Online Comment

Application H18-0085-25
Location Land between East Bank/Gunthorpe Road and Gunthorpe Solar Farm
Walpole Bank PE14 7JJ
Proposal Installation of access track and associated development

Name County Fire Officer
Address Lincolnshire Fire & Rescue Grantham Fire Station Harlaxton Road NG31
7SG

Drawing Title:
Indicative Access Cross Section

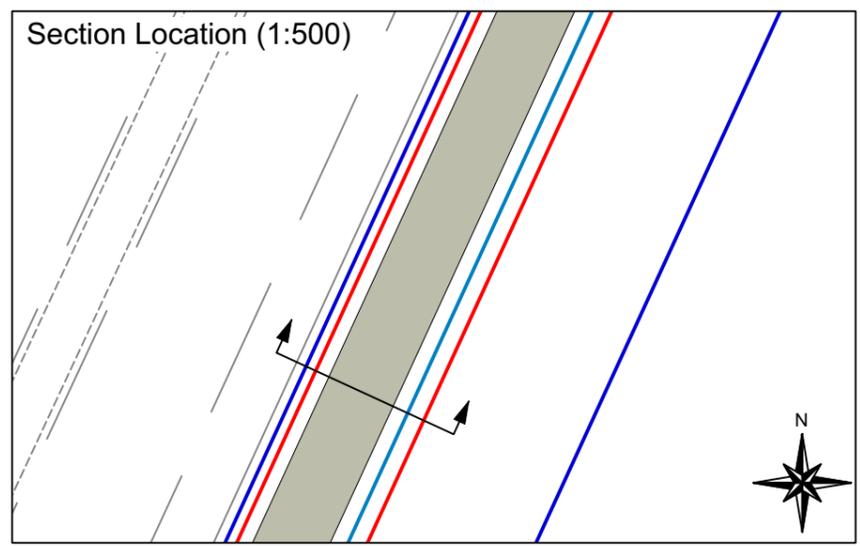
Lincolnshire Fire and Rescue requires a minimum carrying capacity for hard standing for pumping appliances of 18 tonnes, not 12.5 tonnes as detailed in the Building Regulations 2000 part B5.
